**WEST SUSSEX COUNTY COUNCIL
STRATEGIC PLANNING CONSULTATION**

SUBJECT: BR/41/13 - Demolition of existing buildings and redevelopment of the site with 6 x two bedroom dwellings.

Land to the rear of Homelea, Town Cross Avenue, Bognor Regis, West Sussex, PO21 2DN

6no two bedroom houses with 9no parking spaces

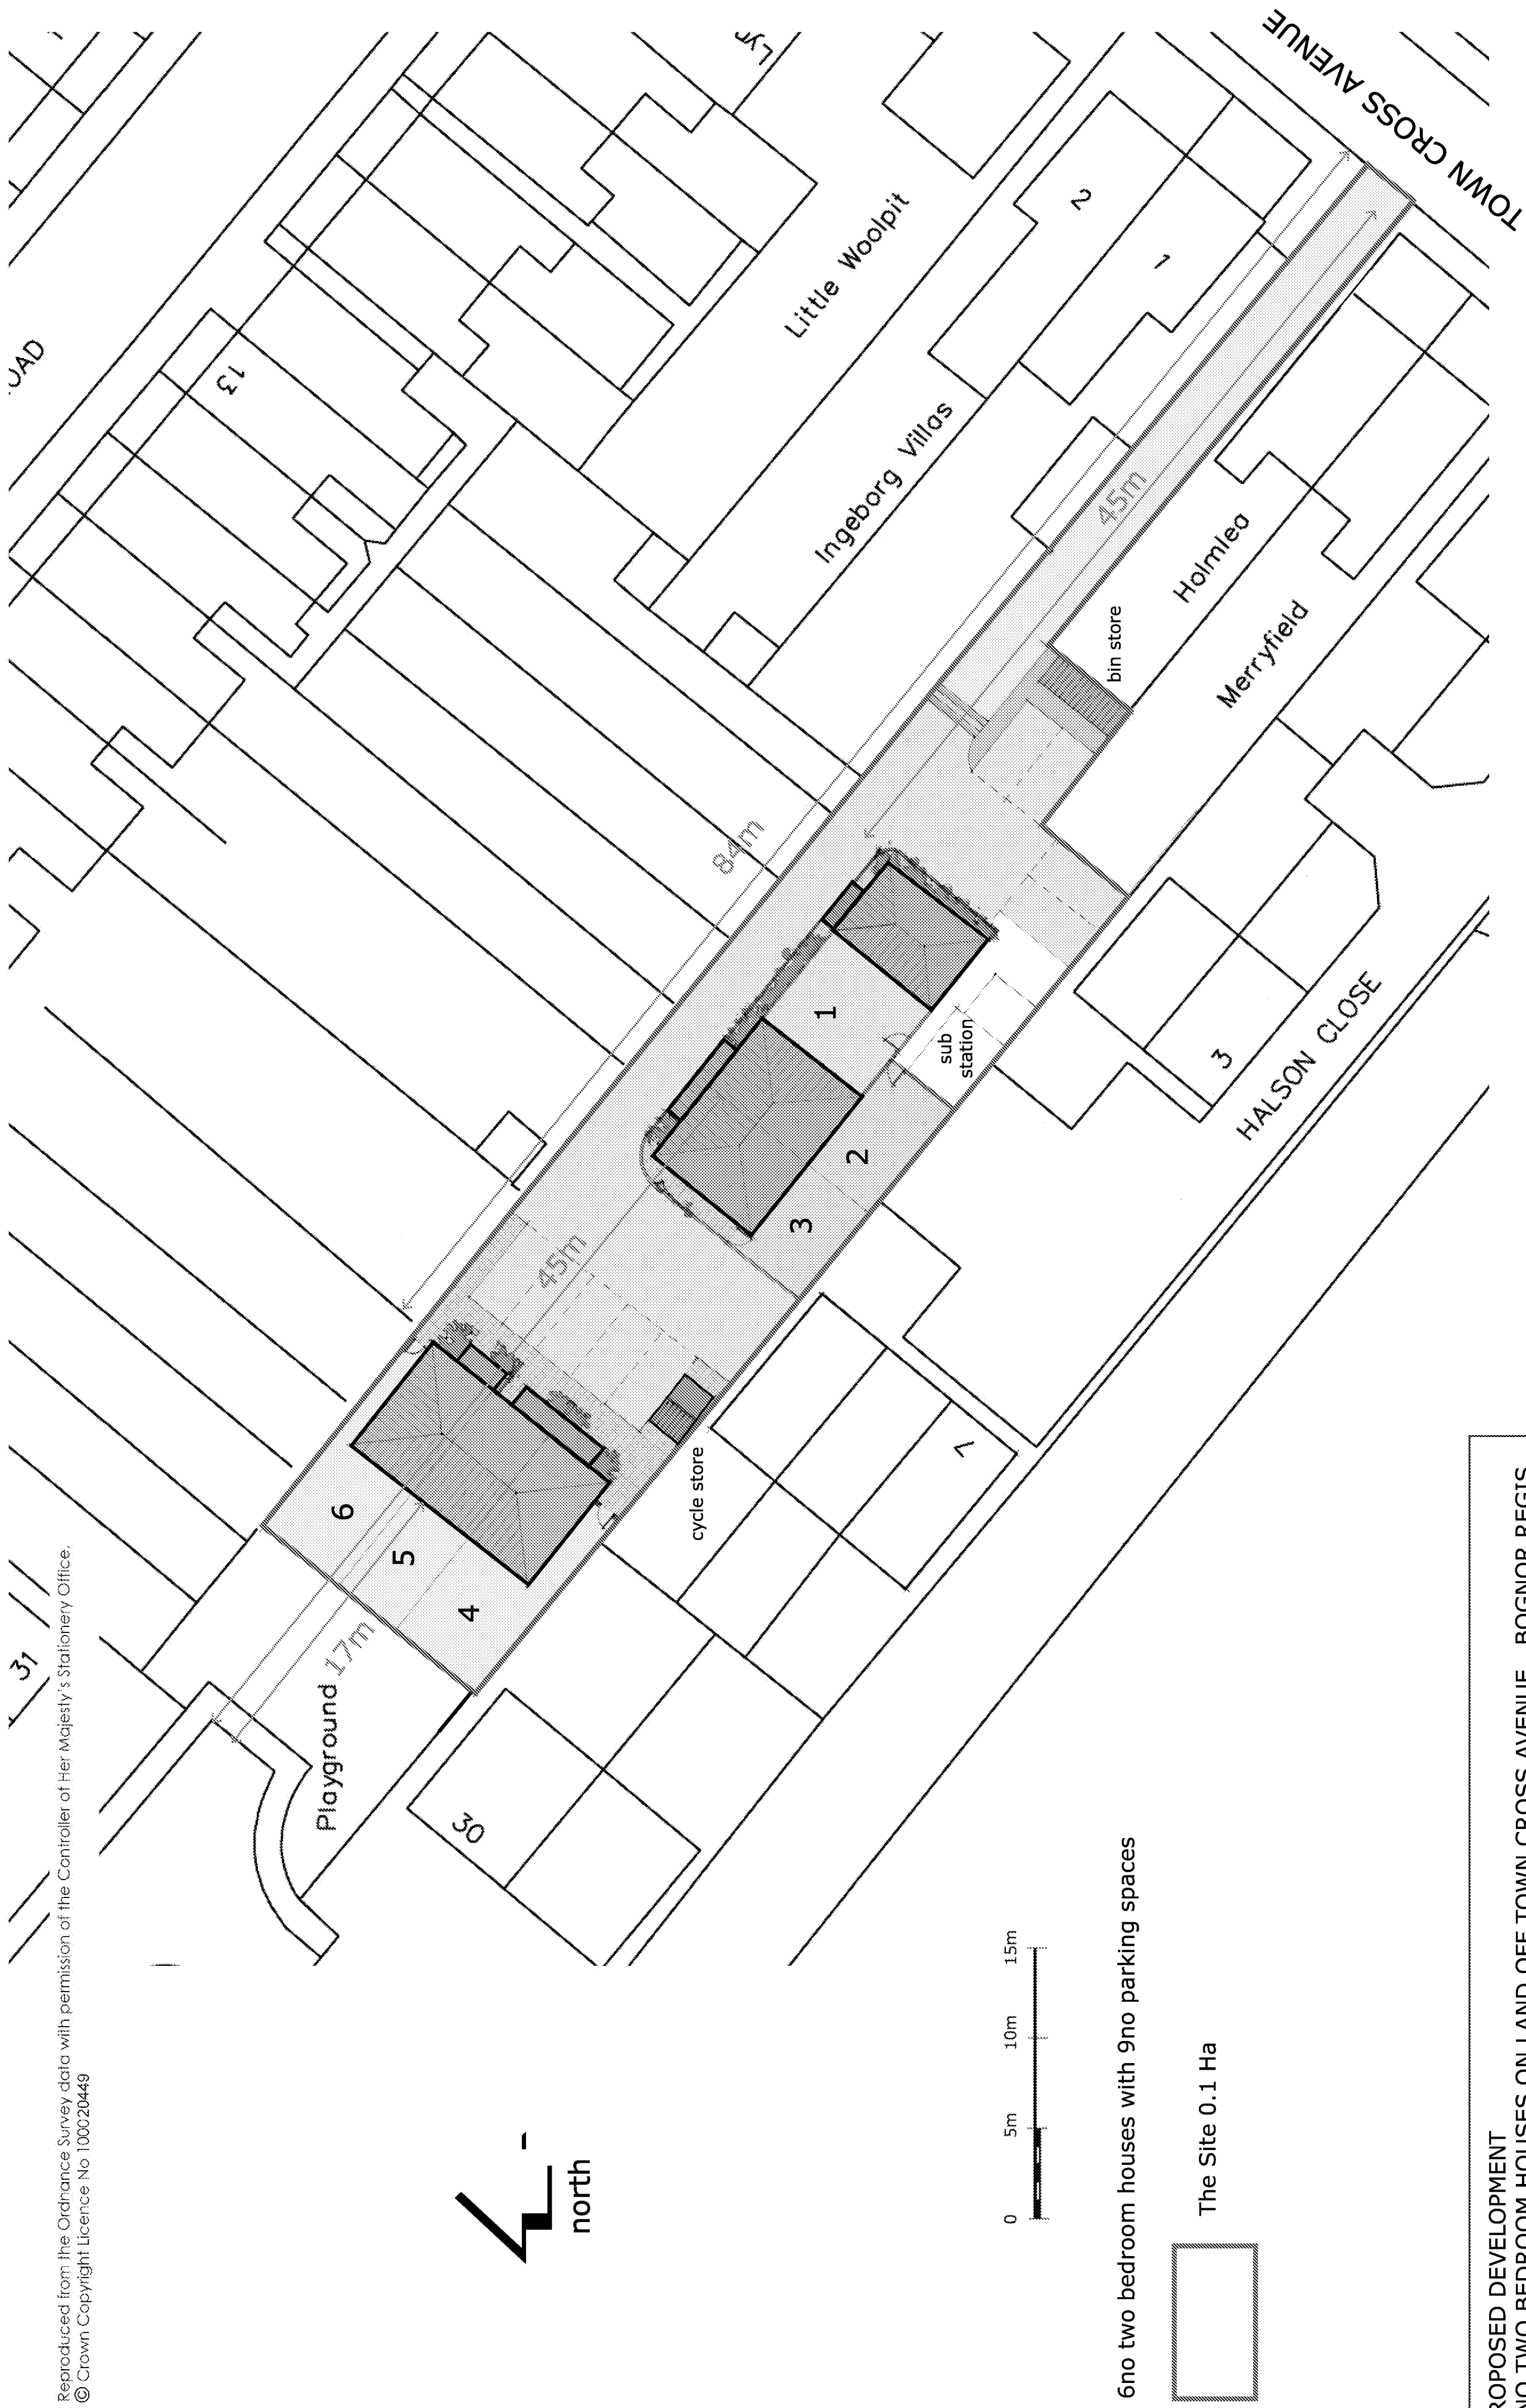
- 1) Although the proposed access is existing, and the number of trips generated from 6 dwellings is unlikely to have any material impact on the highway. WSSC would like to know what visibility splays are achievable from this access onto the highway. The design and access statement indicates that the visibility splays will be within the applicant's control. These should be set back 2.4m from the centre of the carriage way (2m minimum) and drawn to the nearside kerb in both directions.

- 2) The width of the access road has not been indicated and as a guess it appears to be too narrow or only just within guidance. We need clarification to make sure a fire appliance can enter and turn within the site in the event of a fire.

- 3) Please provide swept path diagrams showing how a fire appliance will move within the site. We need to know the appliance can enter the access road from the highway as well as being able to turn within the site without over

Cul-de-sacs - turning facilities should be provided on cul-de-sac roads exceeding 20m in length. This can be a hammerhead or turning circle designed on a minimum road width of 3.1m. This turning facility should be provided within 20m of the end of the access road so that fire service vehicles do not have to reverse more than 20m.

- 4) Please provide evidence of where bicycles will be stored that is secure and covered. This development would require 1 space per dwelling.
5) WSCC car parking calculator indicates that for 6 x 2 bed houses we would expect there to be a parking demand for 9 cars. Therefore the current number of car parking spaces associated with the development is accepted by WSCC.
